STATE OF NORTH CAROLINA DEPARTMENT OF TRANSPORTATION

Addendum No. 1

RE: Contract # C203977 WBS # 53022.3.1 F. A. # NHPIM-0040(050) **Johnston County (I-5781)** I-40 From SR-1010 (Cleveland Road) To West of SR-1211 (Morgan Road)

October 17, 2017 Letting

Drawing file: 100 Roadway Plans / 100_009_I-5781_RDY_PSH_2A-1.pdf

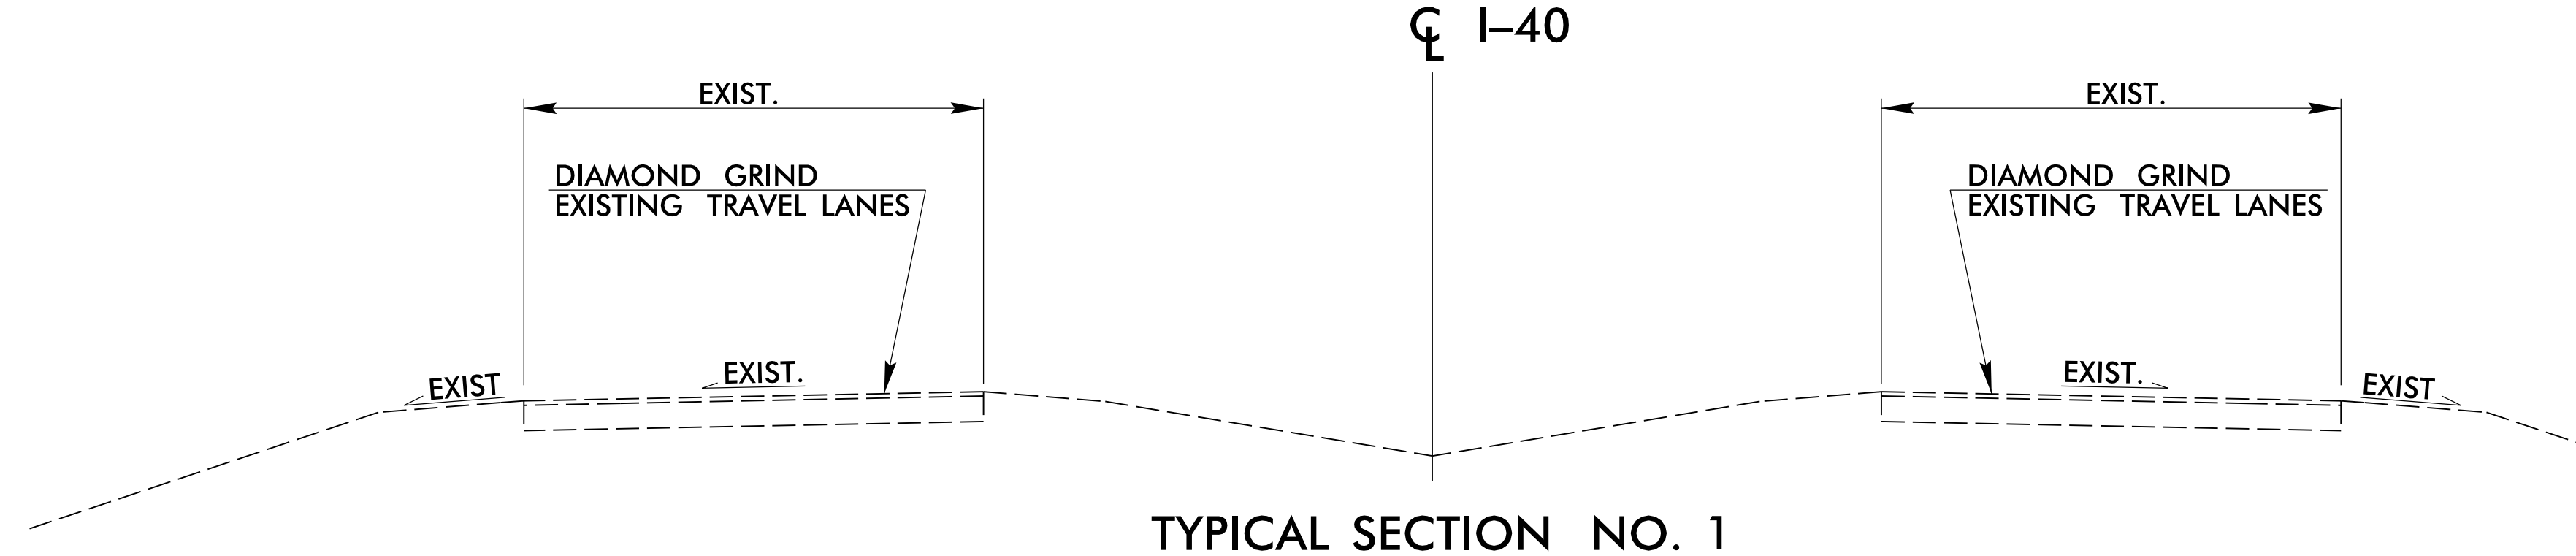
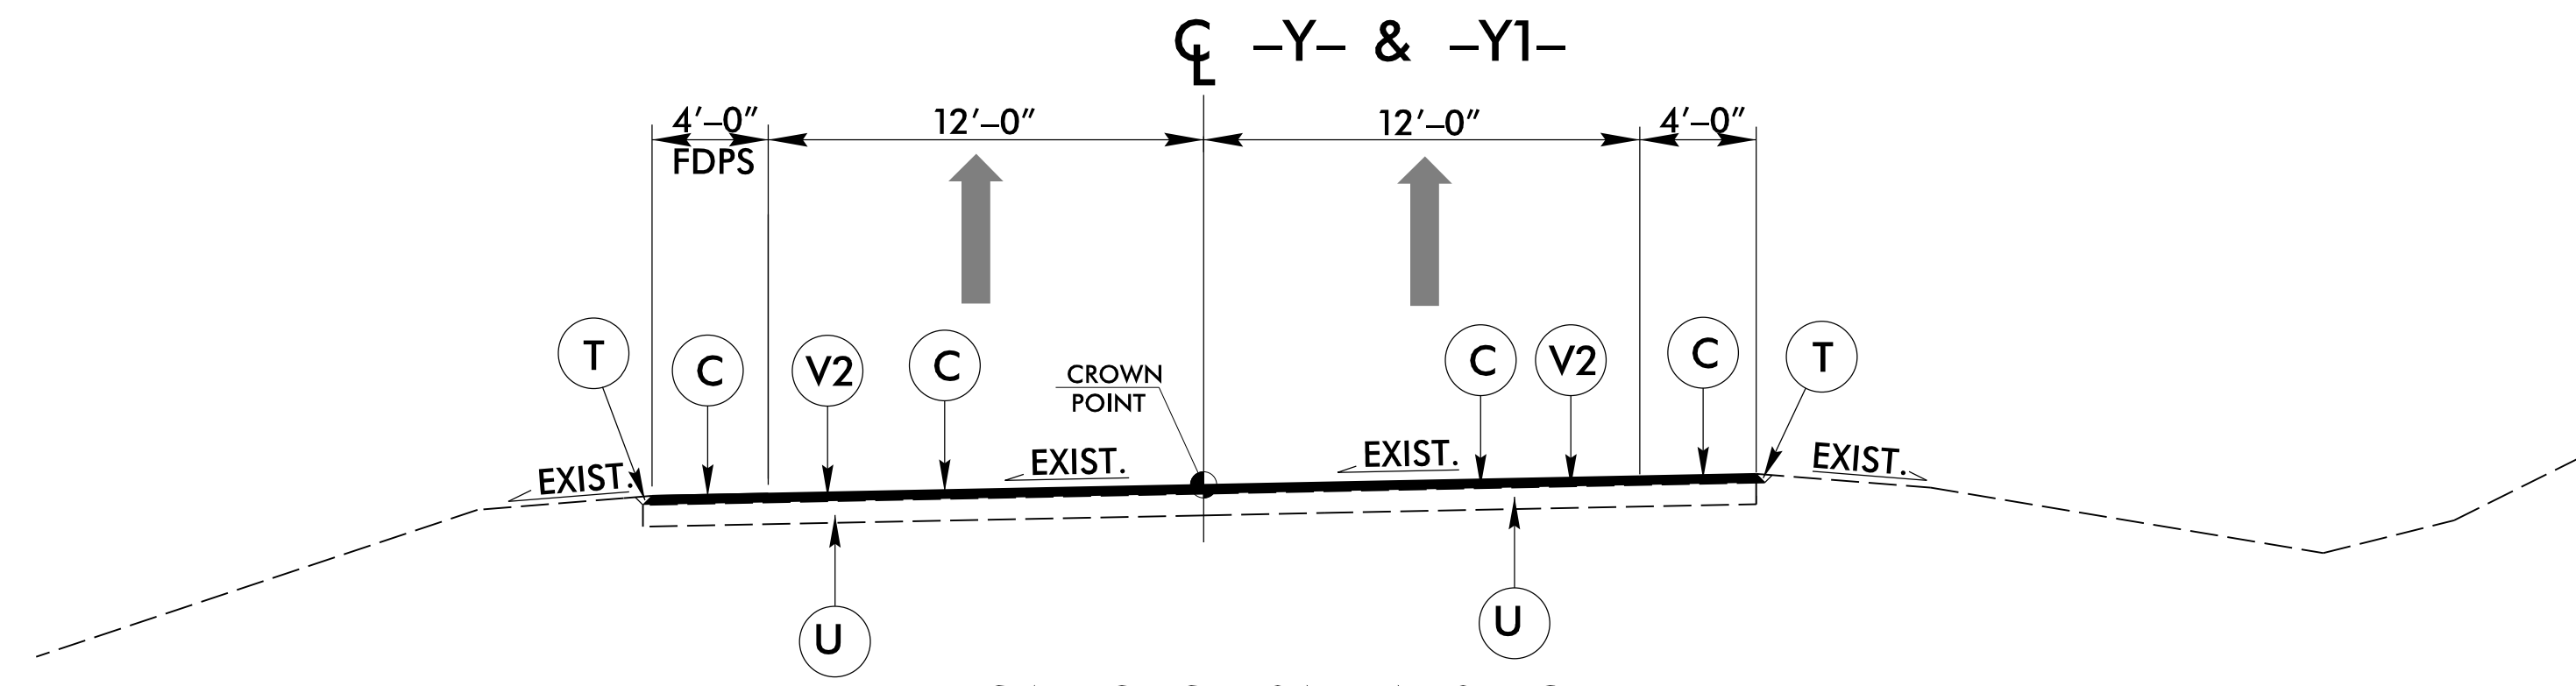
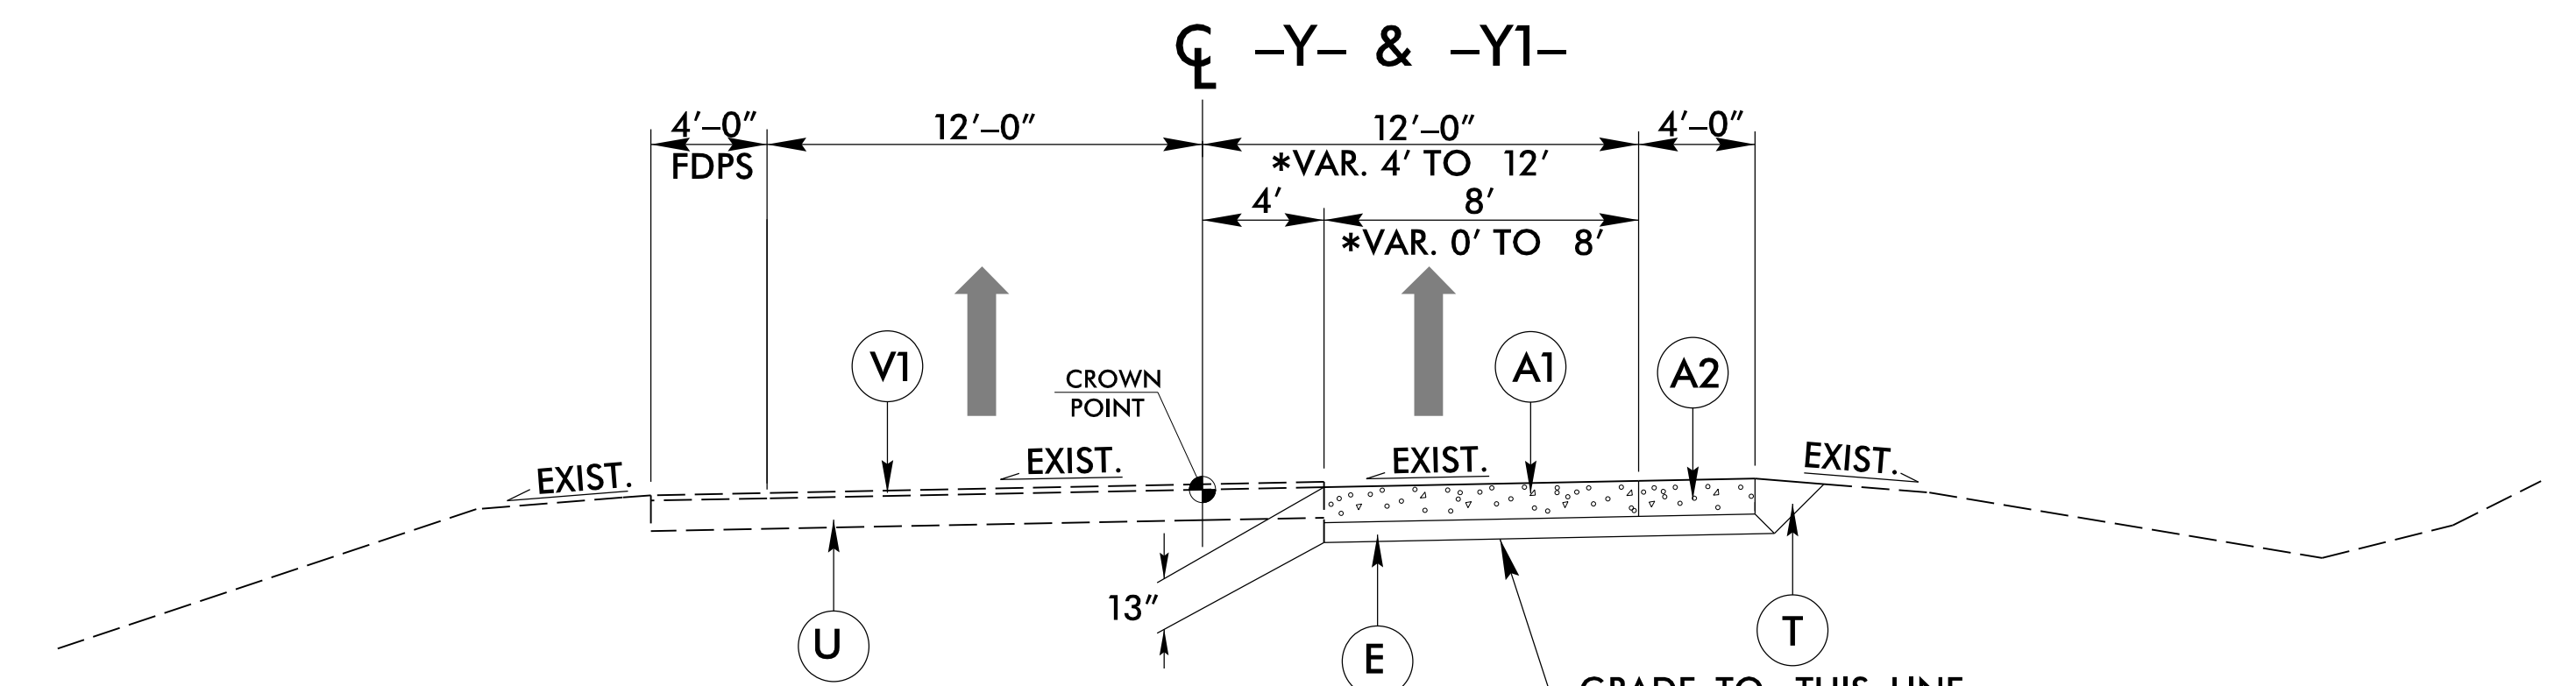
Sheet No.	Revisions	
2A-1	Revised to add Note #5	
PMP-1 and PMP-2	Revised to reflect the change in pavement markings as noted below
